Final Acceptance Punchlist

El Paso County – Department of Public Works – Stormwater Section

Project Name:	Widefield Park & Rec Improvements
EDARP File Number(s):	PPR2213, CON2261, ASB2316
ESQCP Number:	ESQ2250
Attendees:	DPW SW: Ben Jones DPW Development Services: N/A Developer: David Gish, Nuun Construction, Todd Kimes (LKA Architects), Jim Houk
Date of Walk-through:	04/08/2026
Walk-through Number:	1st

C7.4

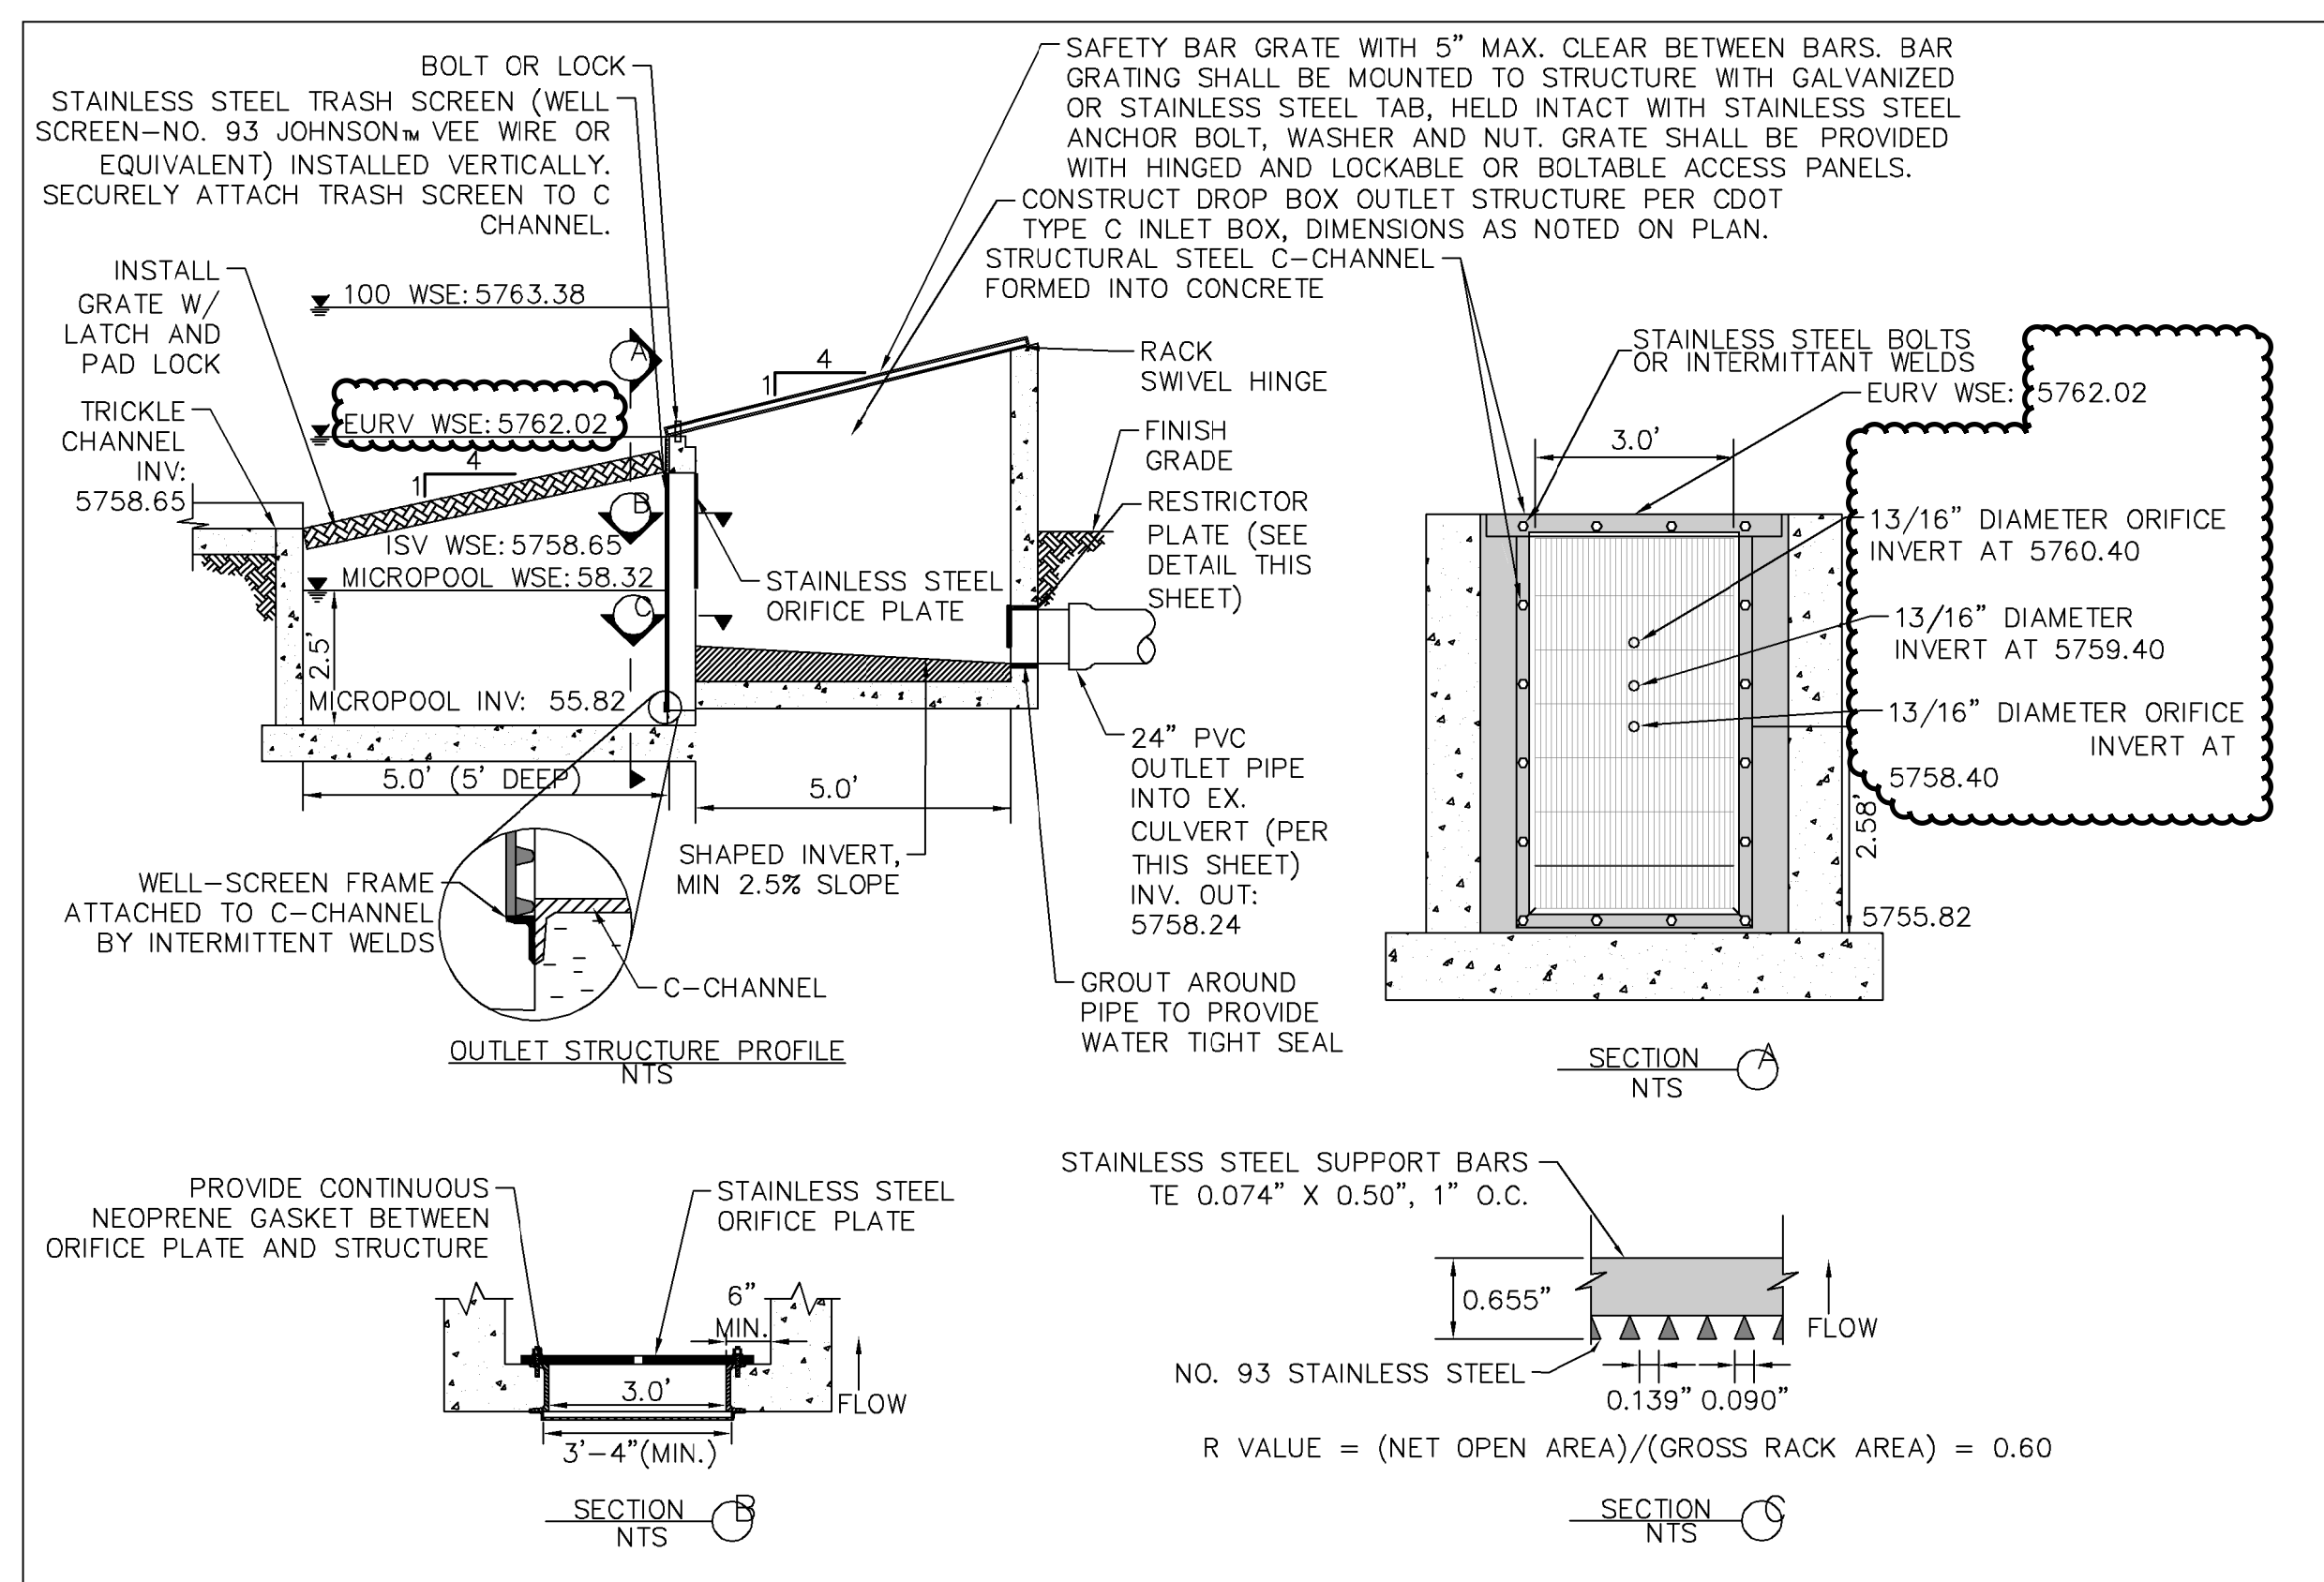
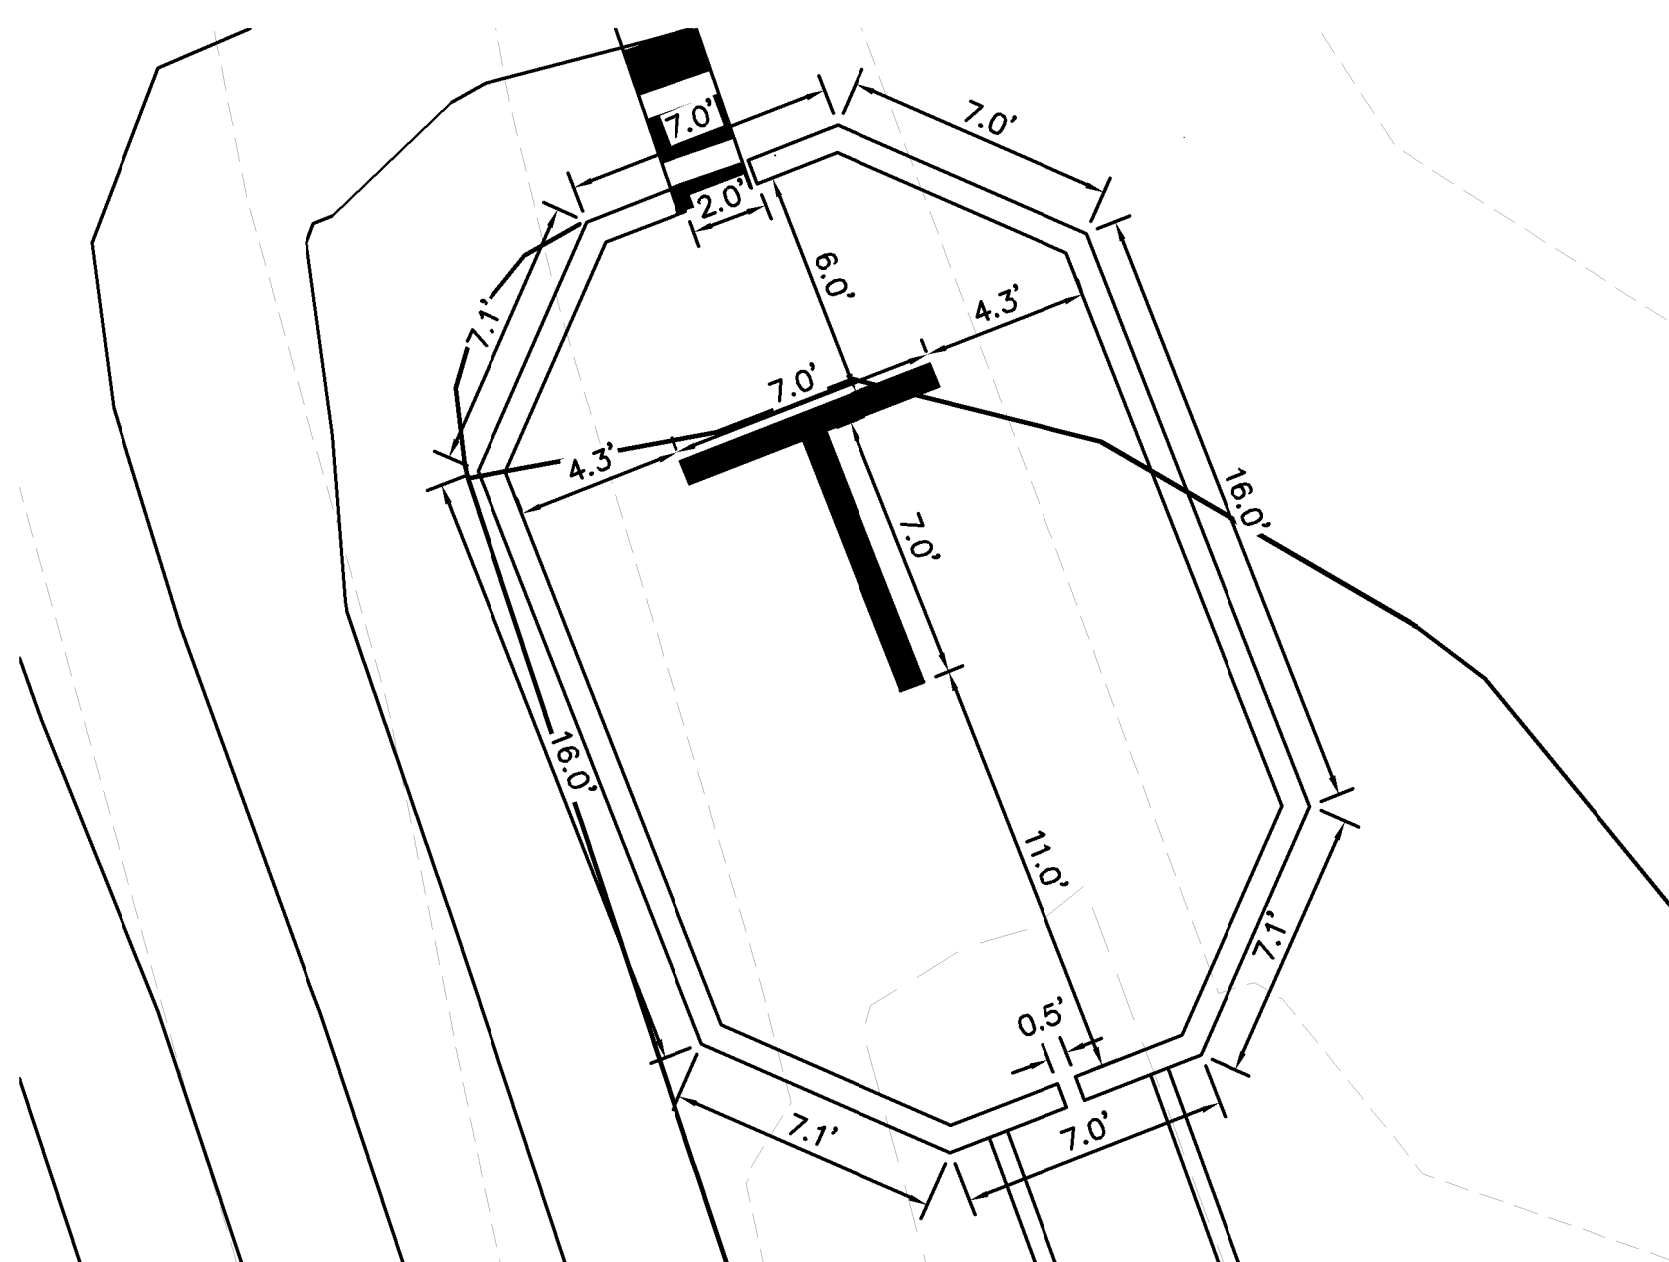
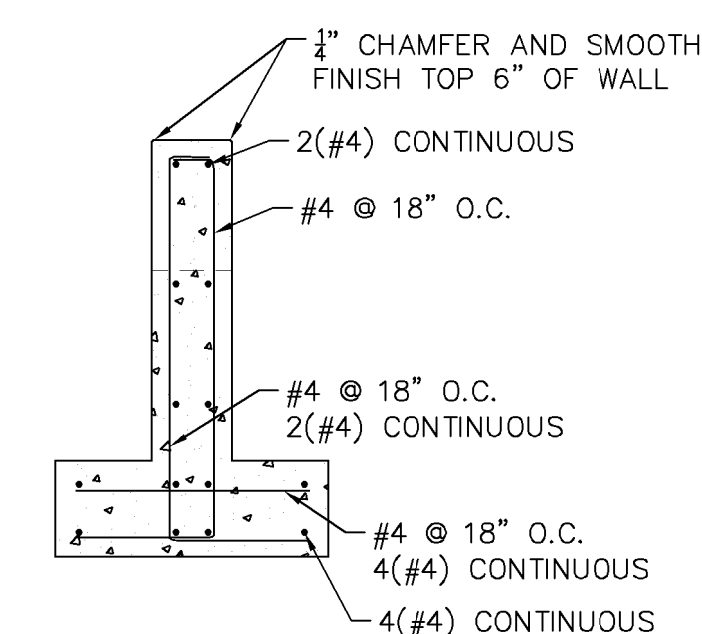
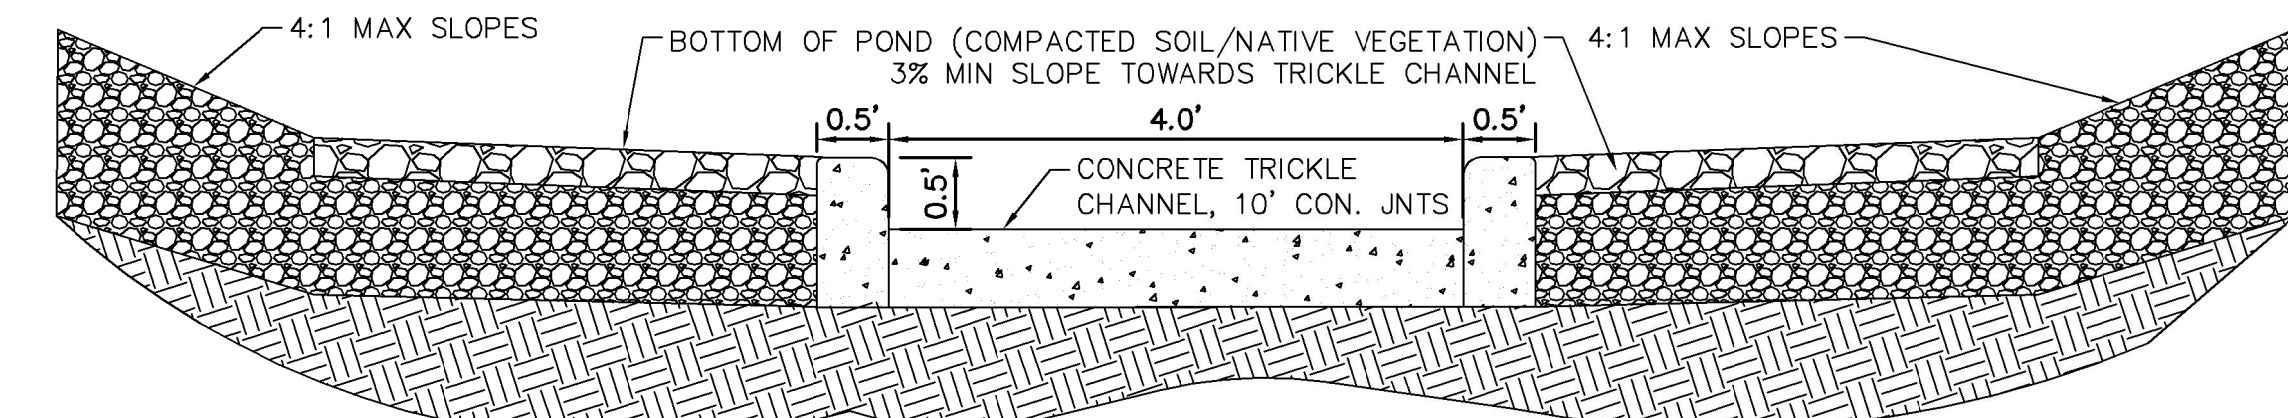
Final Acceptance
South Side
we only requested that the crossmember gap (ie: the gap at the top of the outlet structure between the orifice plate and the microscreen, in the horizontal plane) be covered up, not anything in the vertical plane. Please clarify why this was done. Sheet #C7.5]:

- Outlet Structure
 - Clean Trash Rack and repair lock mechanism. See photo 4.
 - Clean debris from Microscreen. Microscreen is a different material than called out on plans. Plans call for Johnson Vee Wire No. 93. Send updated detail on current screen material or replace per plans. See photo 5.

- Add concrete crossmember to top of outlet structure where missing between microscreen and orifice plate. See photo 6.
 - Orifice Plate Gasket is inadequate and needs to be replaced. See photo 7.

- Microscreen material was welded to orifice plate. Remove material from orifice or consult Engineer of Record.
 - Restrictor plate measures 12 inches above outlet pipe invert. Plans call for six inches above outlet pipe invert.

The relevant elevations need to also be shown on spillway detail on Sht C7.5

KHA Response: McNichols perforated metal screen is an acceptable substitution.

KHA Response: Steel cross member solution proposed by the contractor is acceptable and outlet structure will function as hydraulically intended.

KHA Response: Restrictor Plate specified to restrict 6" from the top of pipe, not 6" clear, and was installed correctly. Refer to the Letter from the EOR confirming this condition.
